Maine Medical Center Bramhall Campus Environmental Graphics & Wayfinding Program

Site Submission

Response to City Comments and Recommendations

City Comments and Recommendations (received Thursday, September 6, 2018)

Option 4: Blade Site Line Study at Entry

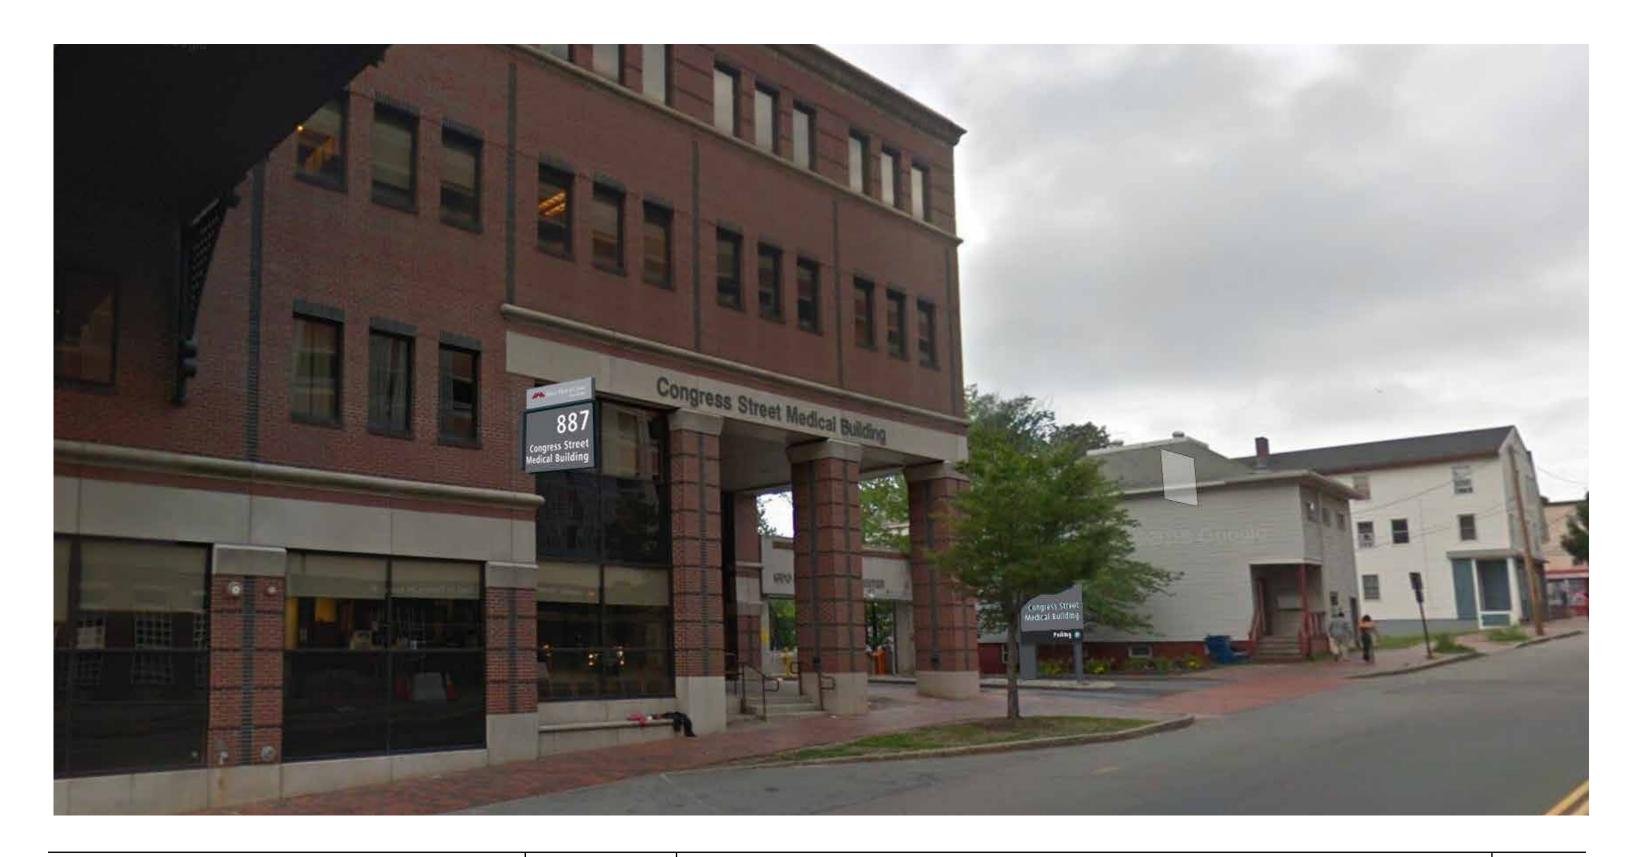
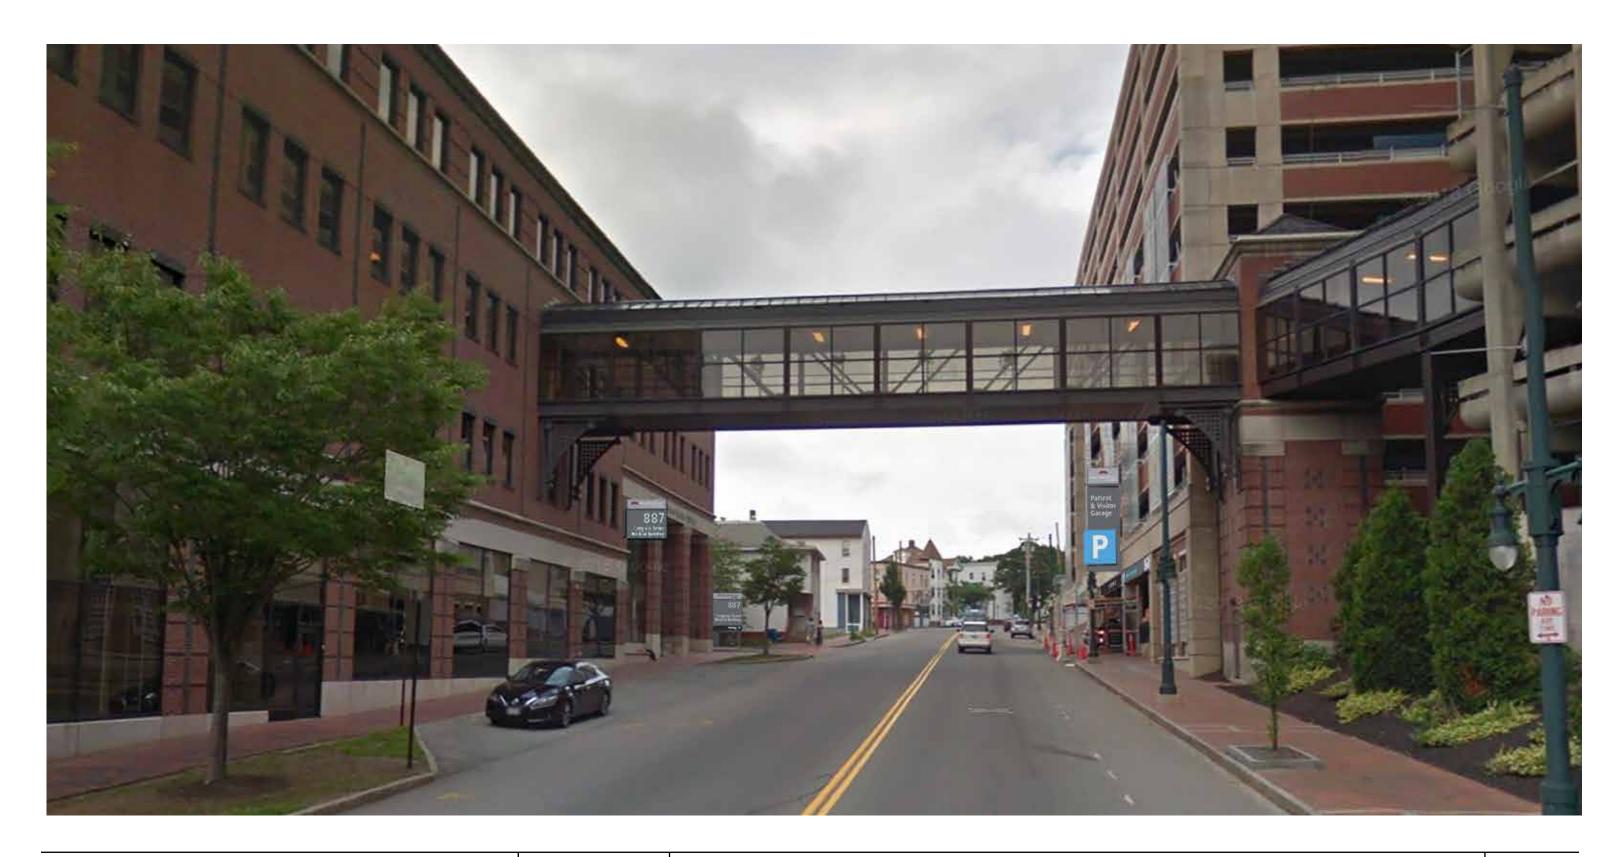
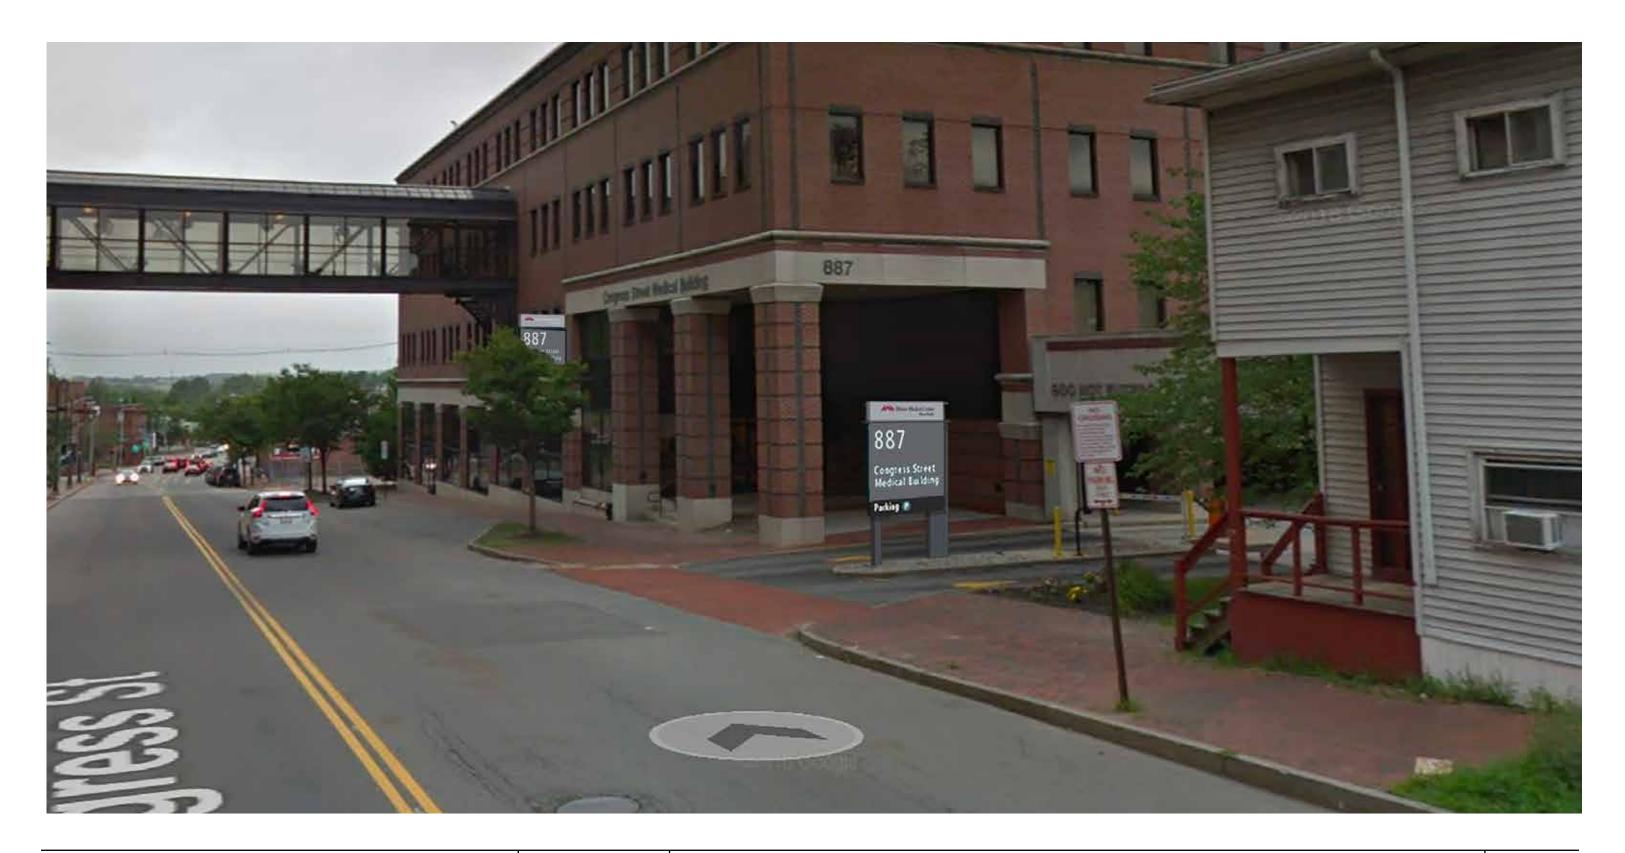
- No signs will be permitted on properties not owned by MMC (e.g. 1b)
- There are concerns about sight line obstructions on several of the signs, including ST.1a, CS.2 and EG.1a.
- Please provide a sight line analysis (Included)
- There are concerns about the size of the signs in general. Could those proposed as 11' in height be brought to a more pedestrian scale (e.g 8'?) There are particular concerns about the size of 4a, which is replacing a much smaller sign and 6a. Both of these signs should be brought to a pedestrian scale
- Eliminate one of the signs marked 5.b and reduce the size of the remaining to the scale of the existing sign
- Please indicate dimensions of CS.1 and method of illumination. At first blush, this sign appears out of scale.
- The layout of EG.1a is inconsistent with the other signs of similar purpose (e.g.ST.3a). Is there a reason for this?
